BURPHAM PARISH MEETING

Ref:- B/30/10/TC 82 The Street, Burpham

① HOLLY TREE

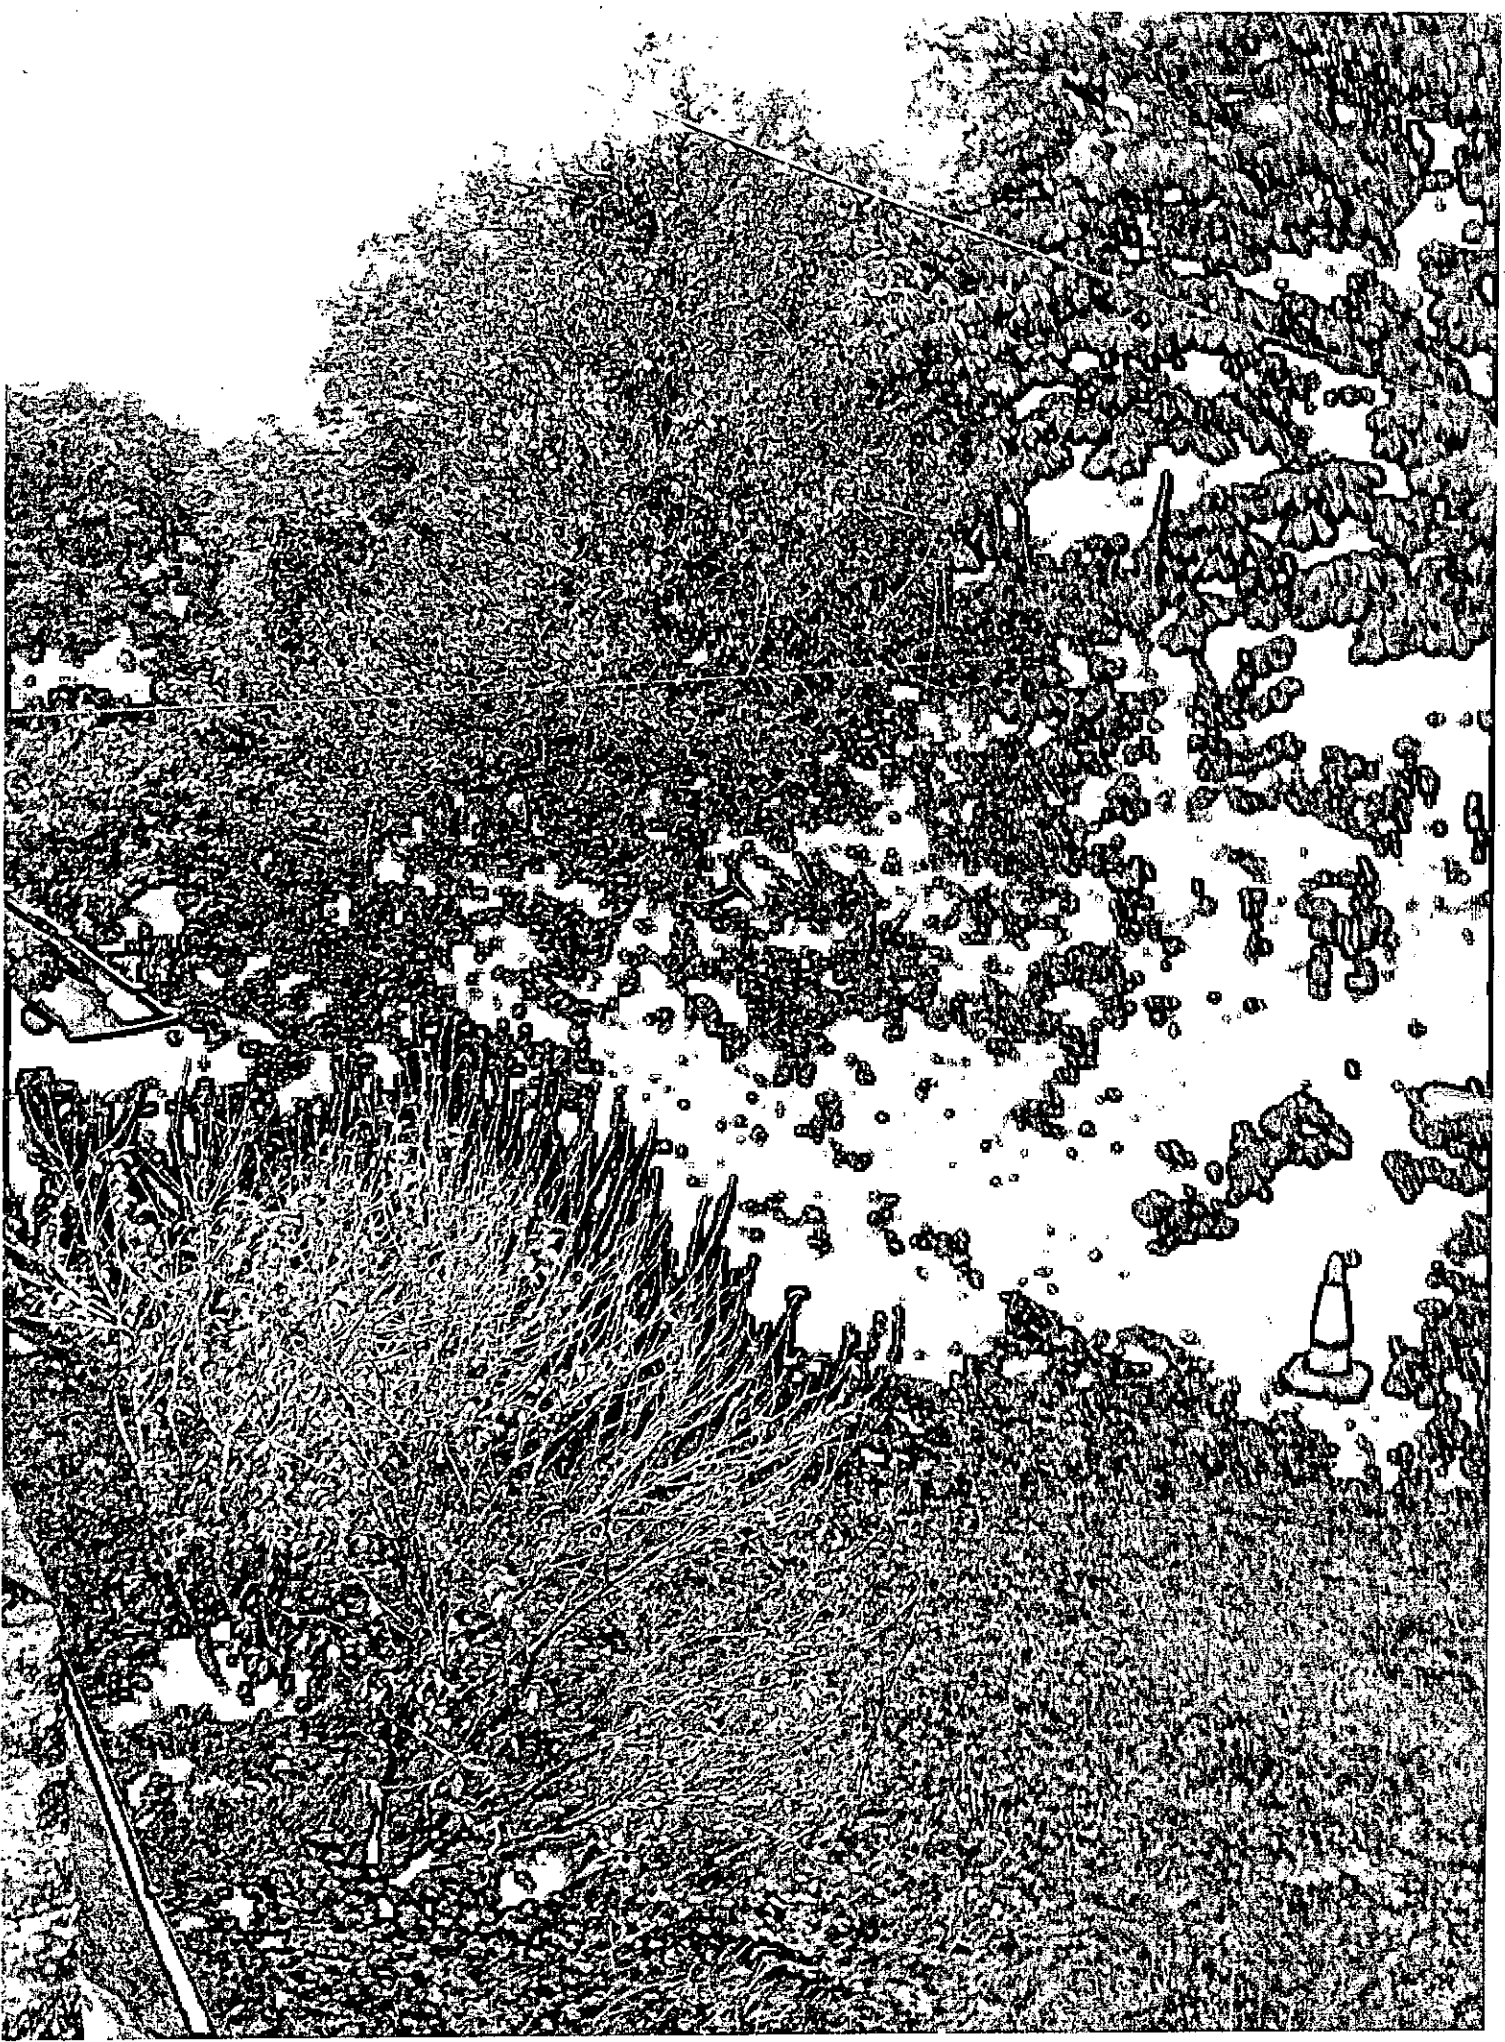
Both the holly tree and the pine tree are badly damaged by ivy. The holly can be saved if trimmed as requested. The pine tree will not recover and could become dangerous if not felled.
